Deadline 6 – Representation

Kent Street Passing Places and traffic Management Plan

Eastern boundary with Kent Street Lane (C-C)

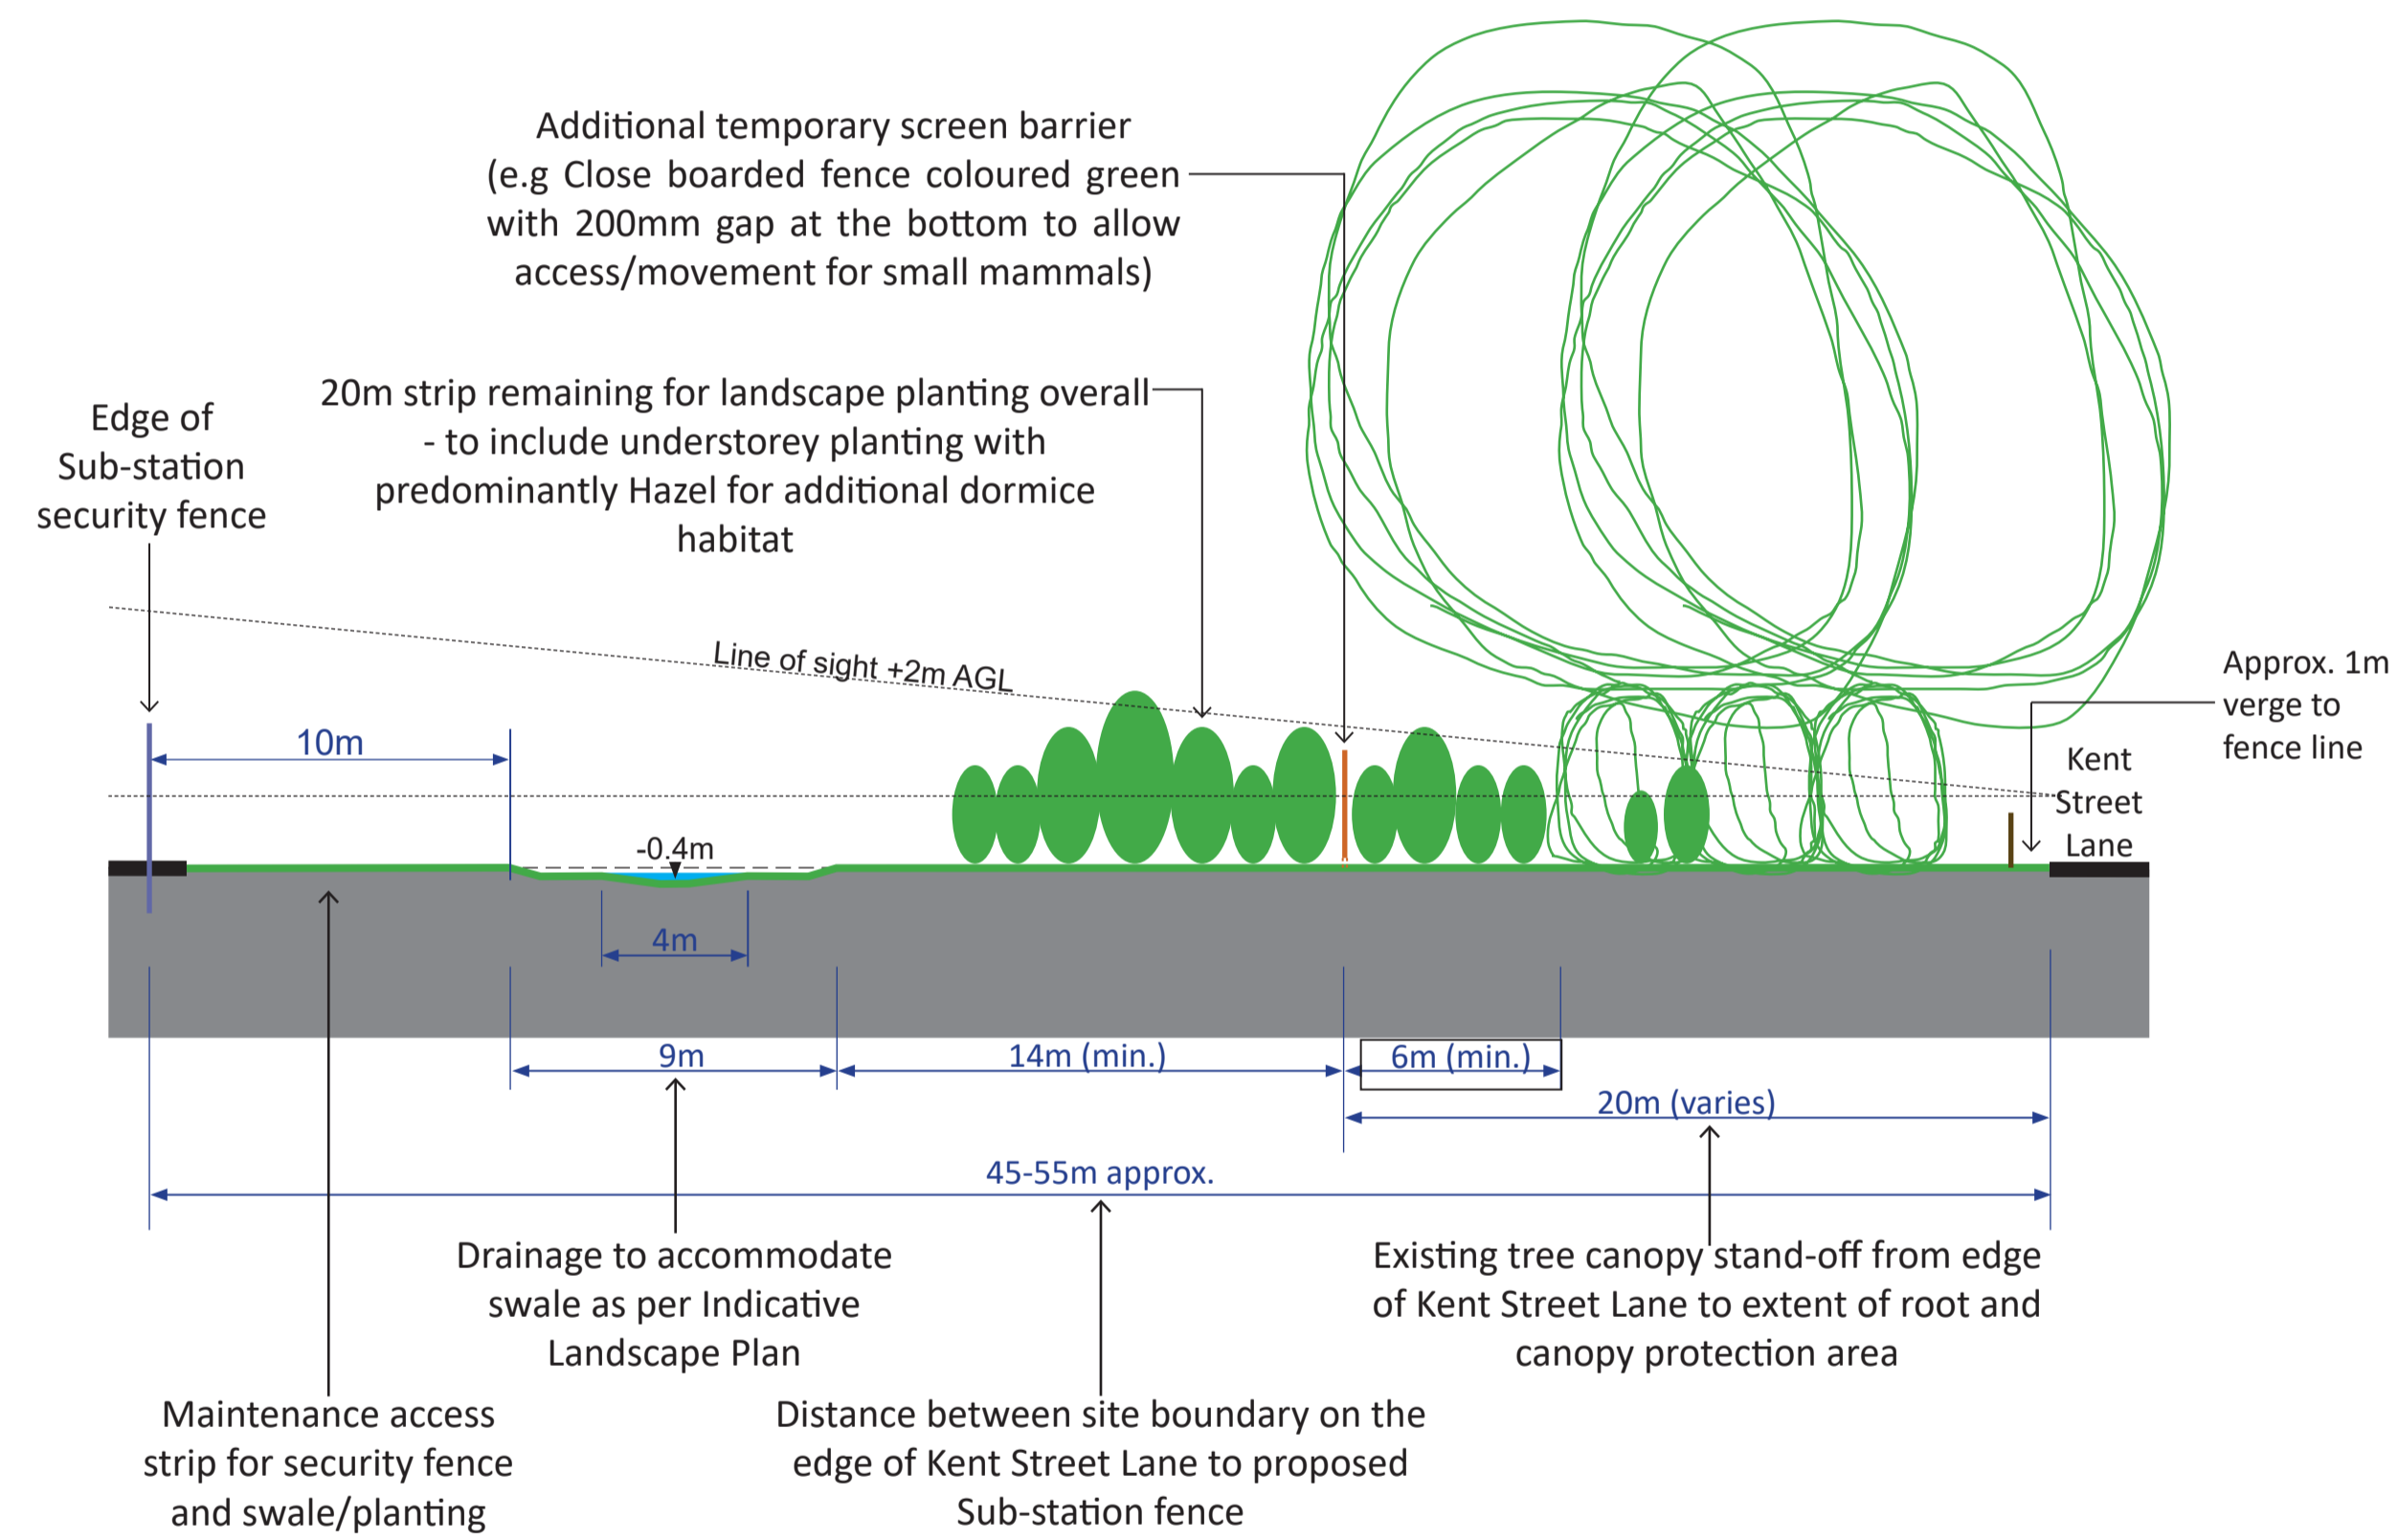
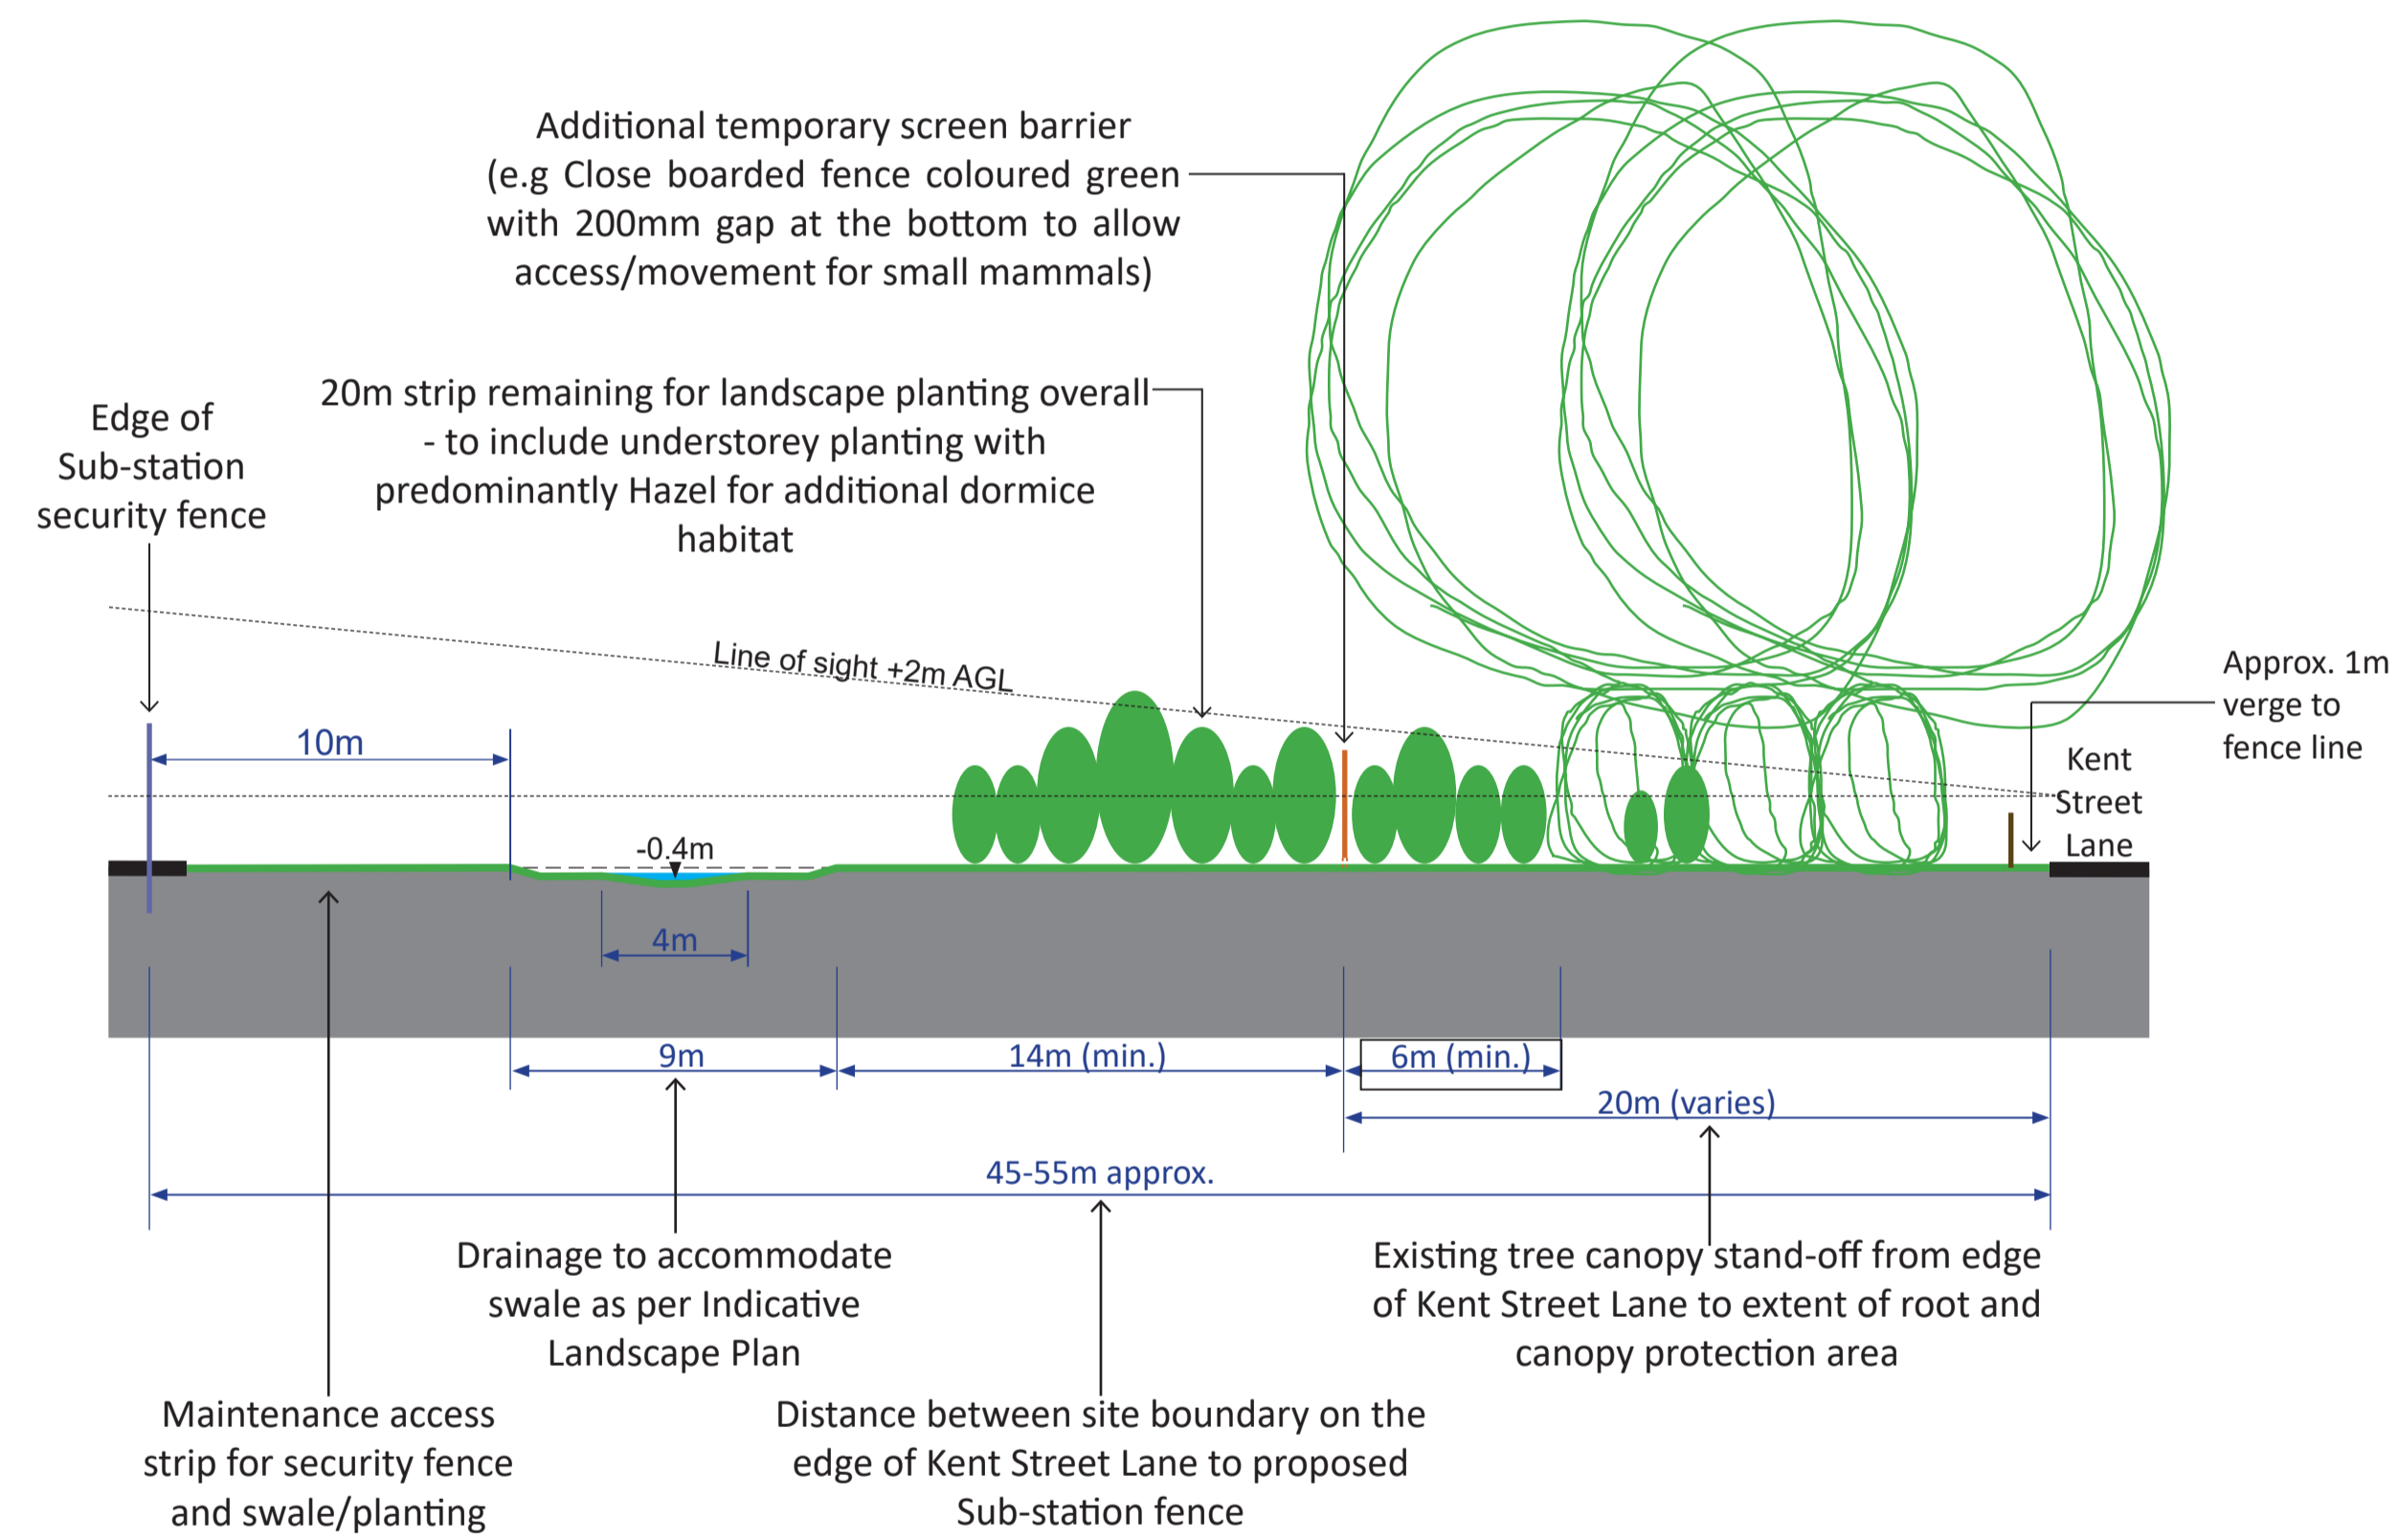
- Increased destruction of hedges and trees not currently accounted for in proposals due to buildability and widths of passing places, at least 4 more mature oaks tree root protection areas to be affected

- Overall negative affect on rural character of the lane to be increased from current proposals
